LU/134/21/PL & LU/135/21/L

The Farm 39 East Street Littlehampton BN17 6AU

Subdivision of a single listed building into 2 No. separate dwellings & essential roof strengthening work.

Drawing Name	Elevations - Existing
--------------	--------------------------

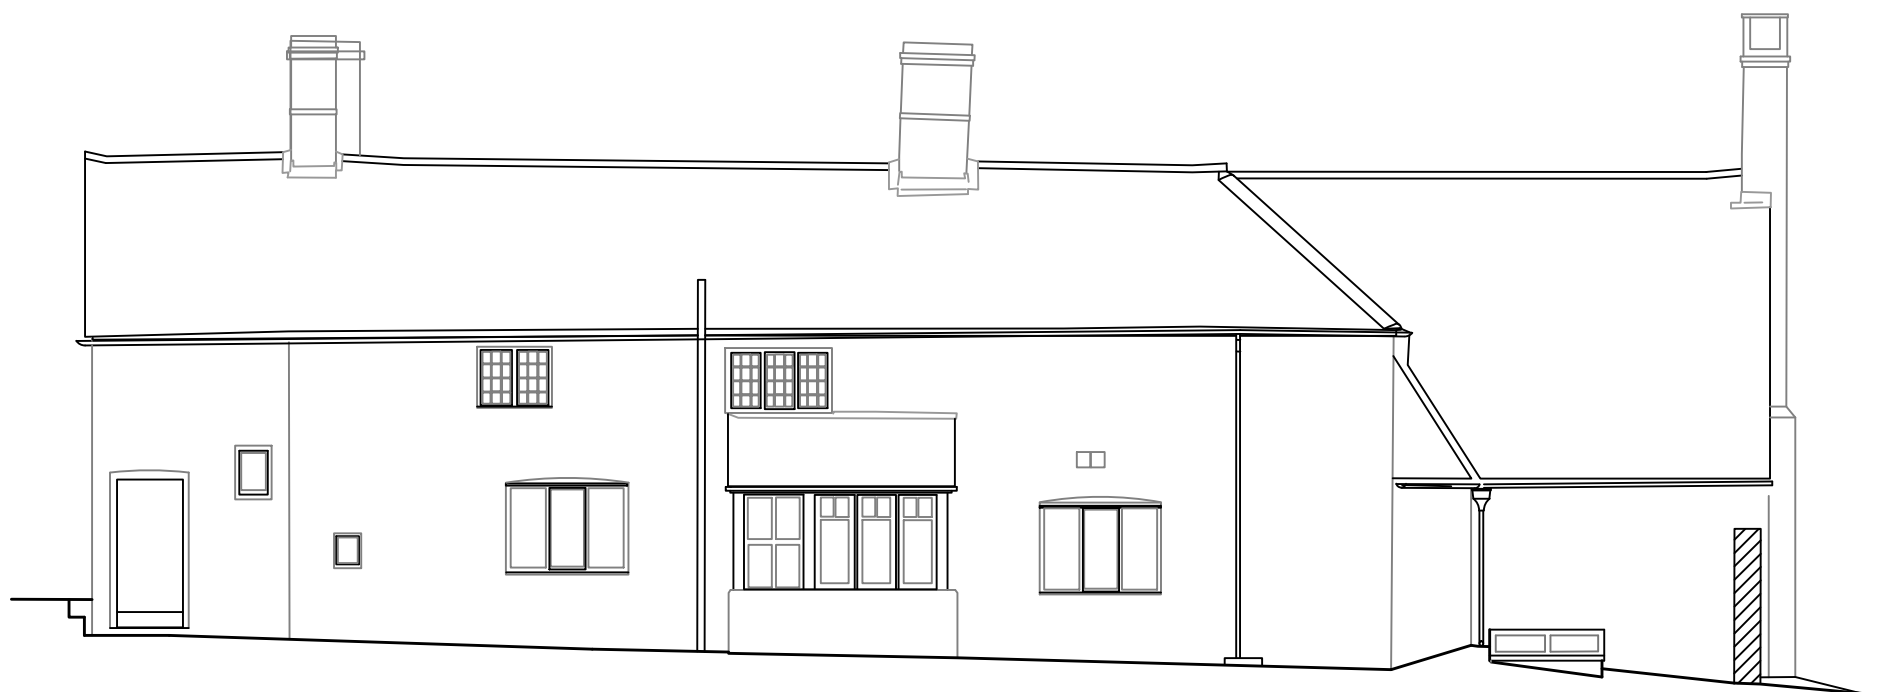
Externally there is very little impact on the building. An additional porch is being added to the west elevation and an additional door is being inserted into the east elevation. These additions will not harm the significance of the listed building and appear to be designed to reflect the existing building. As a result, they are not considered to be harmful. Details of the new external doors and windows and the proposed treatment of both them along with the new porches would be required by way of condition, if minded to approve the applications.

Infill Door Opening Details 1:10

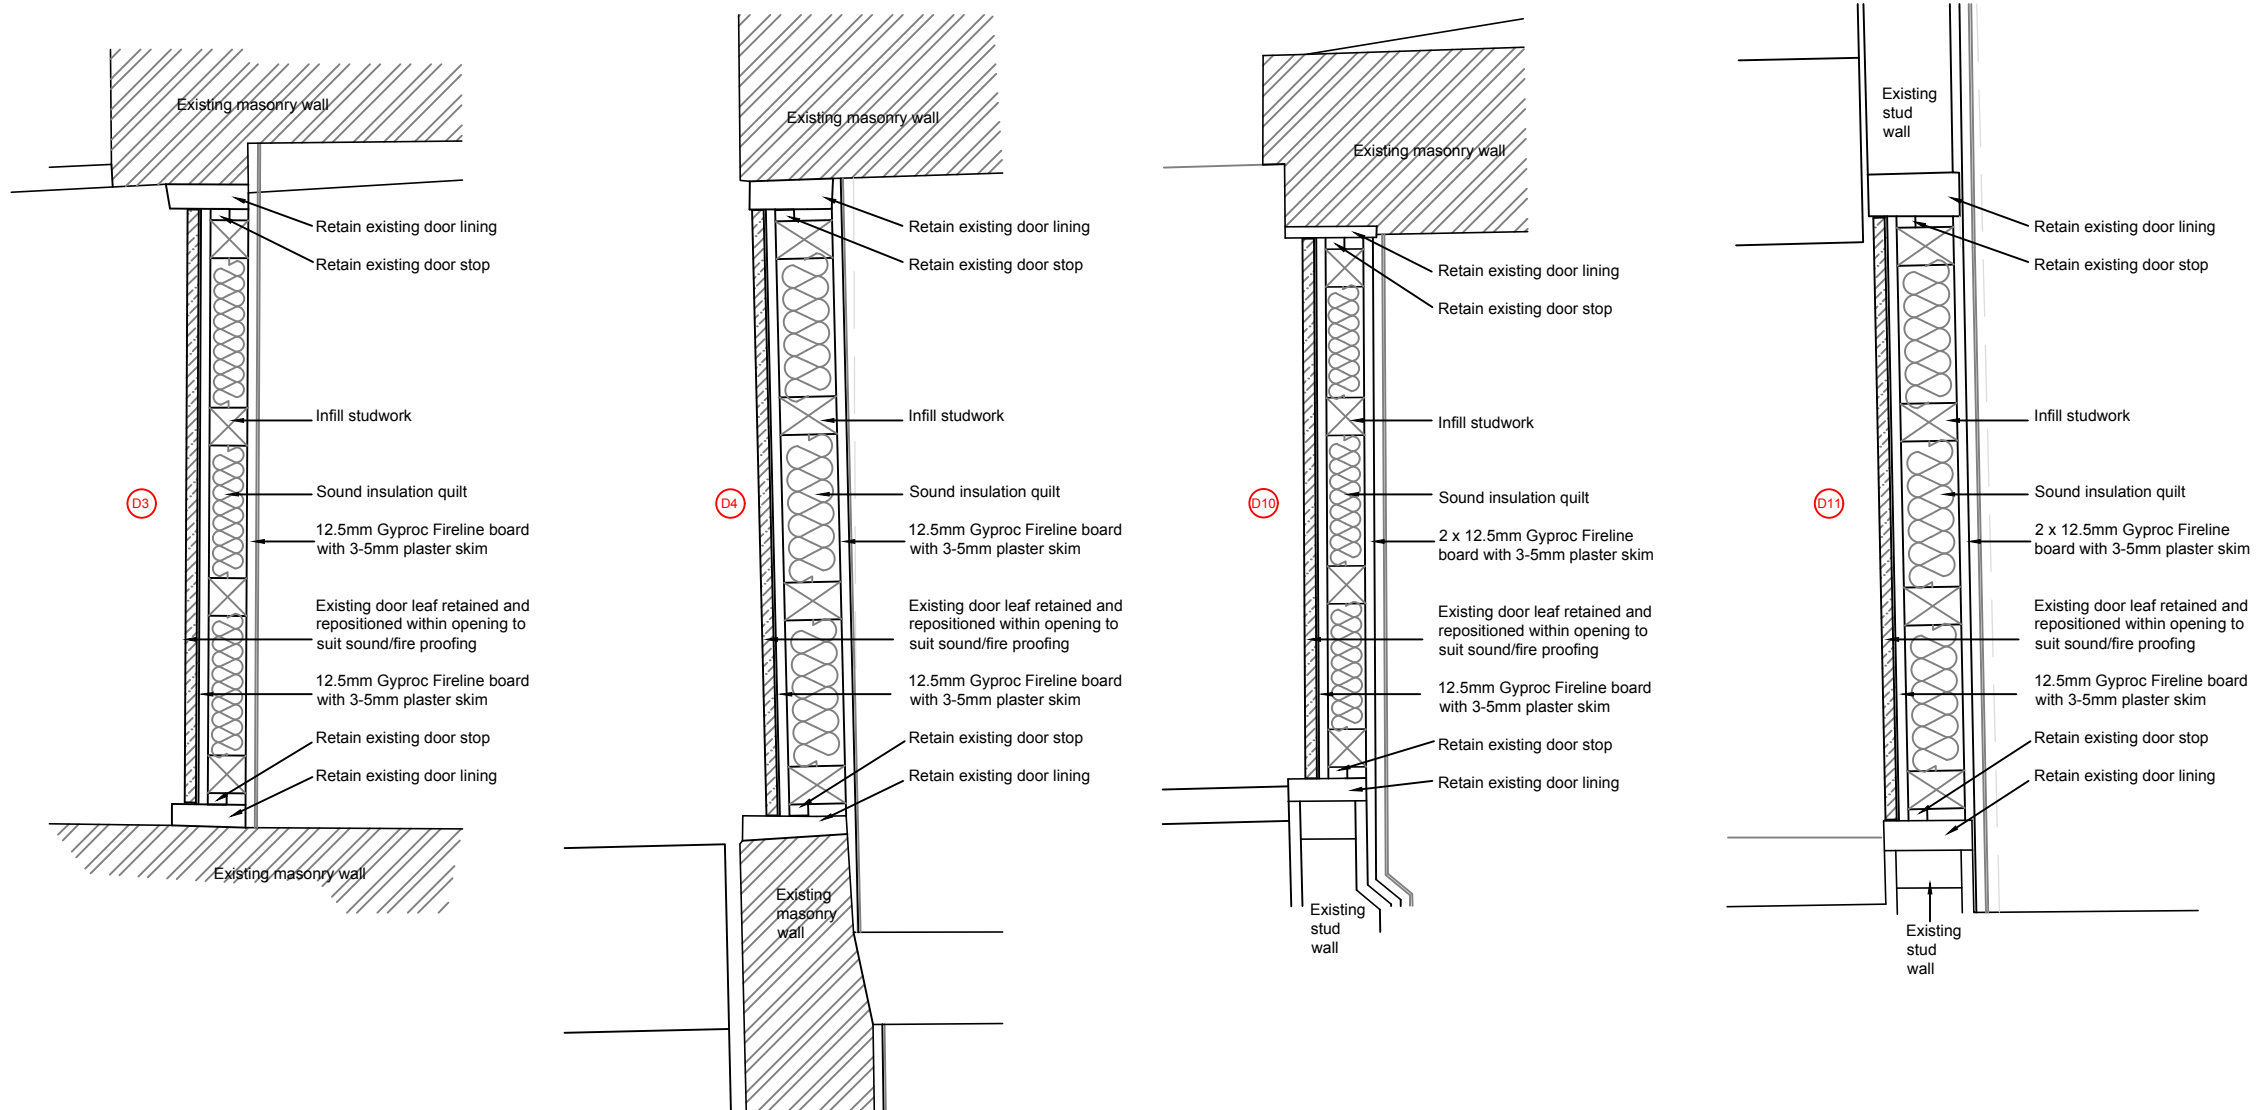
Another proposal which requires an existing doorway to be sealed up involves leaving an impression in the wall to express the former opening. Details of all new internal joinery such as doors and skirting boards should be provided by way of condition, if you are minded to approve the application.

Other alterations such as the blocking up of openings have been designed in such a way that the doors remain 'in situ', with some modern intervention installed behind them. This approach follows good conservation principals as it allows for the works to be removed and the doorway to function again. This approach is acceptable. Other alterations are required as a result of building regulations and have been designed to minimise their impact and to be reversible where possible. Again, this approach is a positive one.
